## OFFICIAL NOTICE OF DECISION

CITY OF ALBUQUERQUE  
PLANNING DEPARTMENT  
DEVELOPMENT REVIEW BOARD

**1. Project # 1004909**  
06DRB-00930 Major- SiteDev Plan BldPermit

HARTMAN & MAJEWSKI DESIGN GROUP agent(s) for SOUTHWEST GASTROENTEROLOGY ASSOCIATES, request(s) the above action(s) for Tract(s) 2A-2A-2B-2, Block(s) 0000, JOURNAL CENTER (to be known as **SOUTHWEST GASTROENTEROLOGY**) zoned IP, located on the northeast corner of JEFFERSON NE between JOURNAL CENTER BLVD NE ANSD HEADLINE AVE NE containing approximately 2.5 acre(s).  
[REF: DRB-97-442, ZA-96-44, 06DRB-00717] (D-17)

**C101**

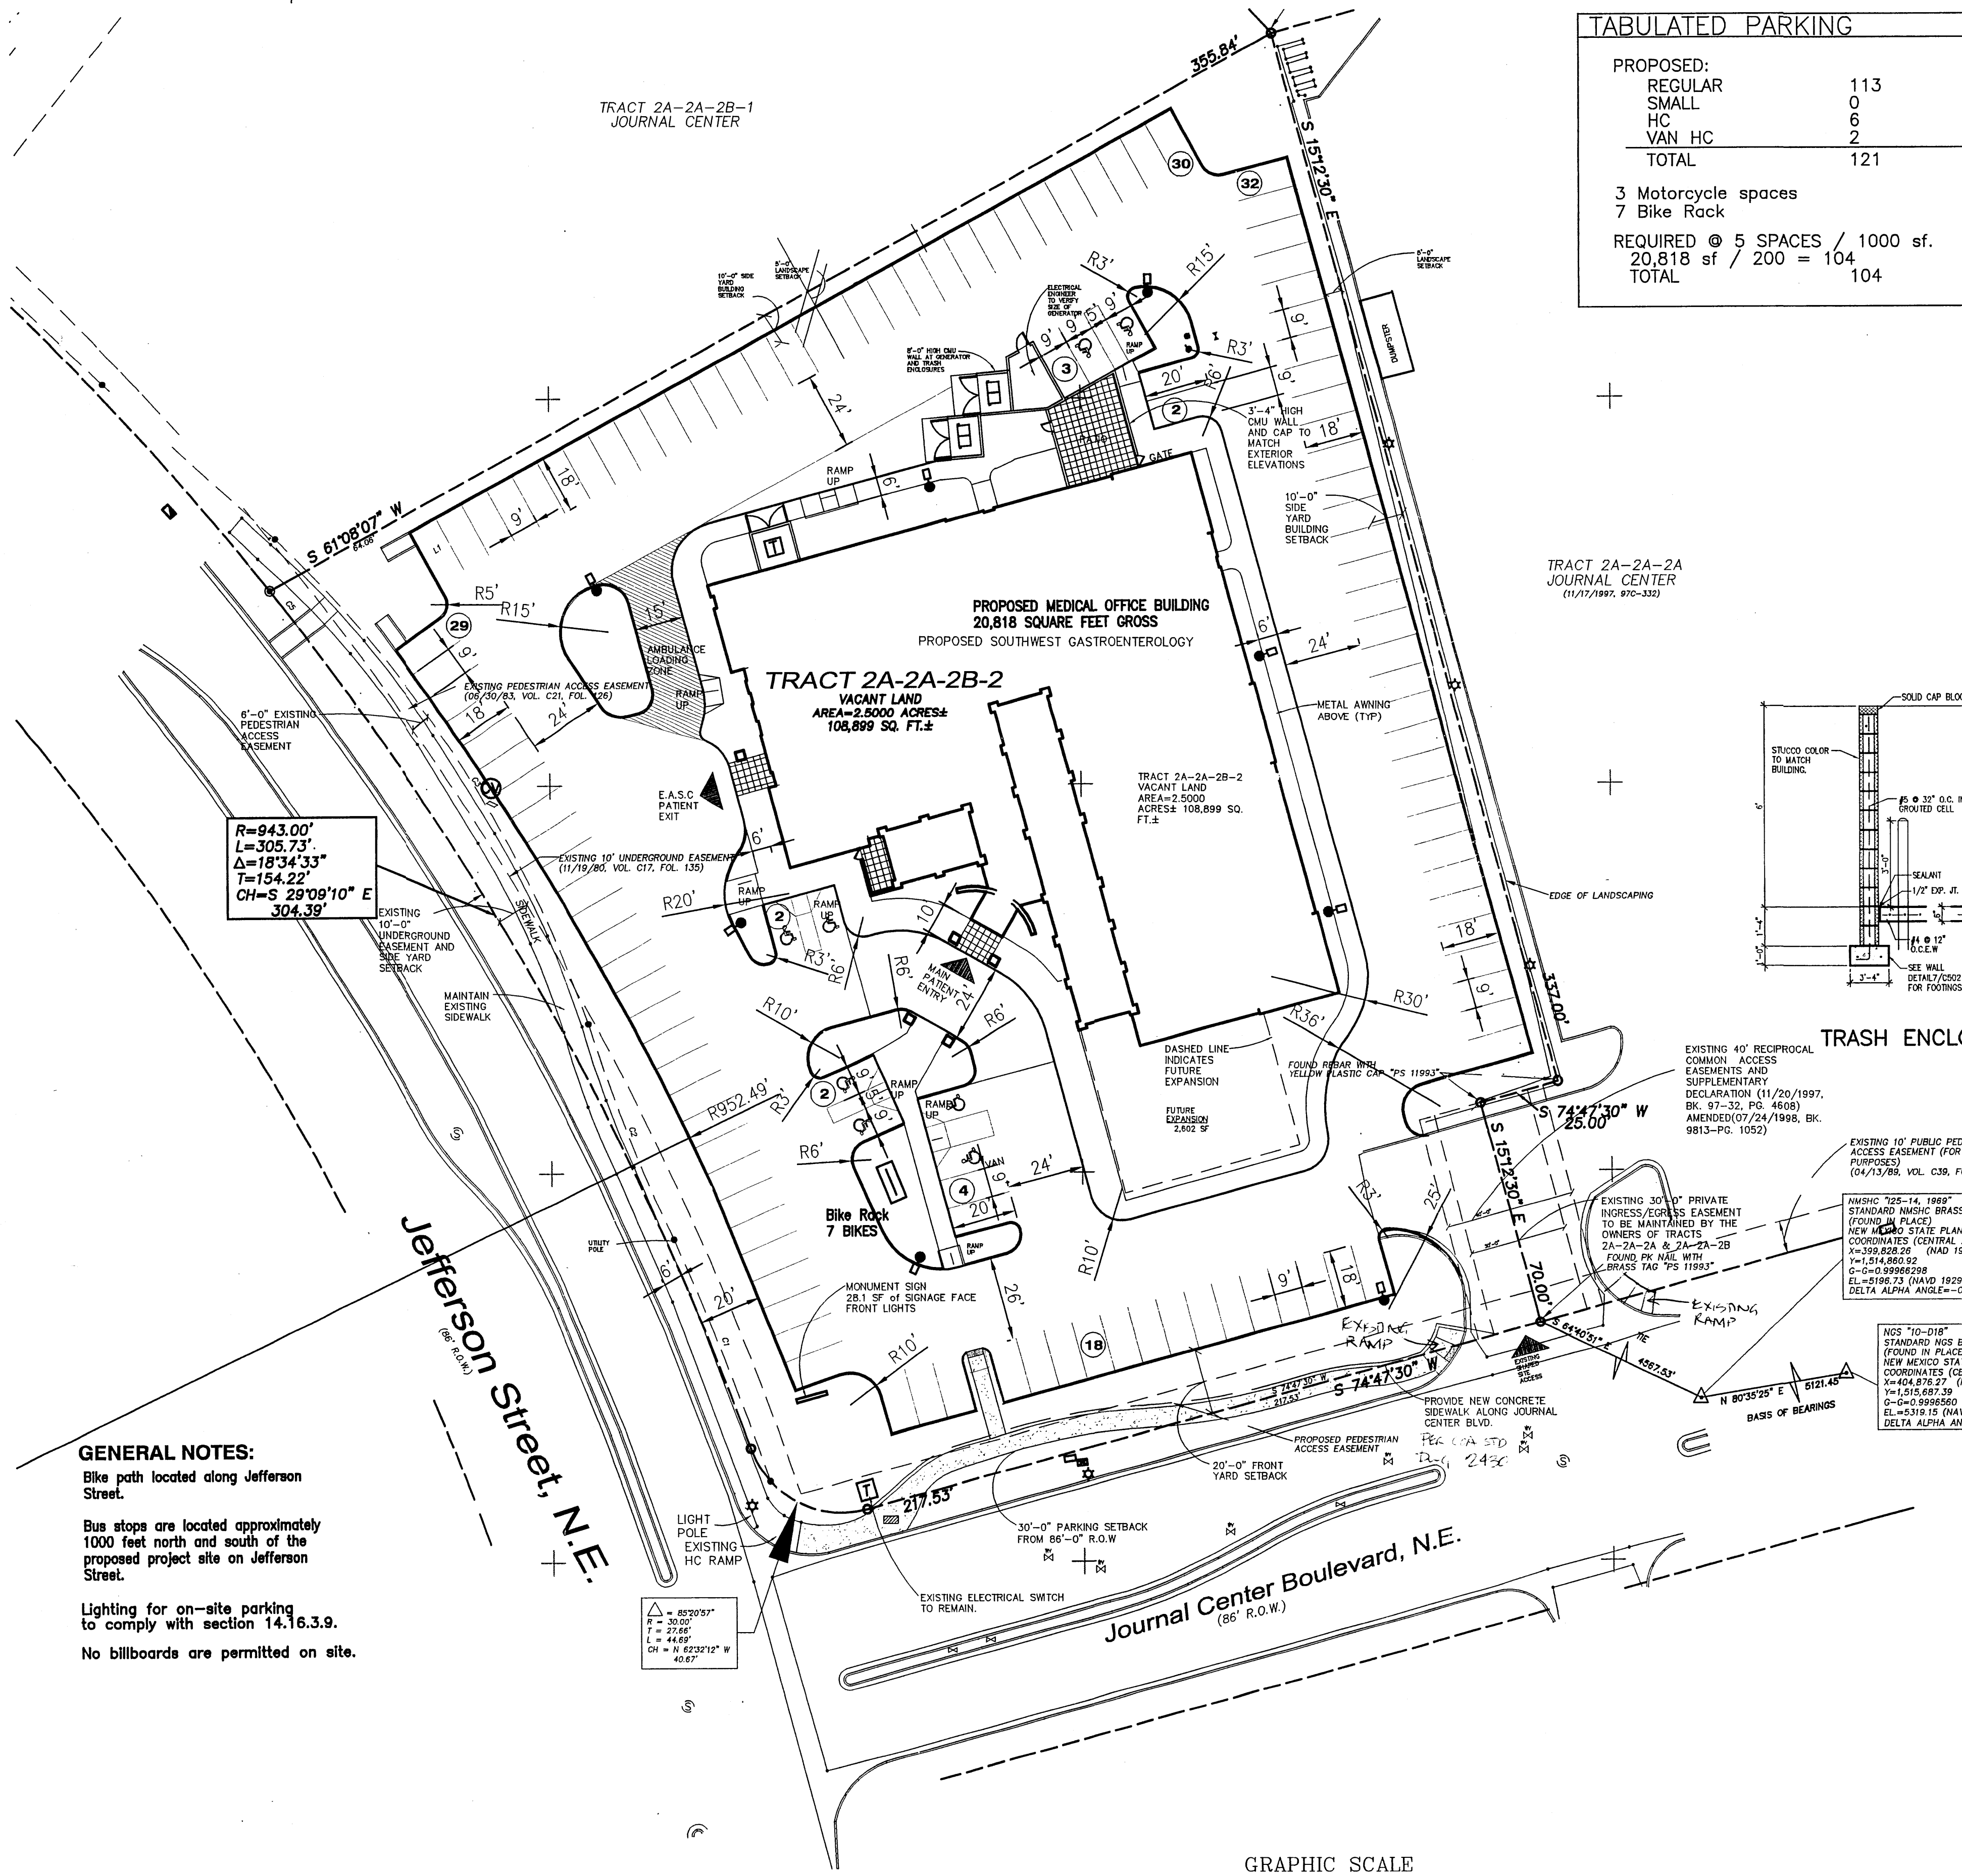
At the July 26, 2006, Development Review Board meeting, the site plan for building permit was approved with final sign off delegated to Utilities Development for fire flow calculations and revised utility plan and Transportation Development for build notes, sidewalk easement, Journal Center approval letter, 3 copies of the site plan and the 15-day appeal period.
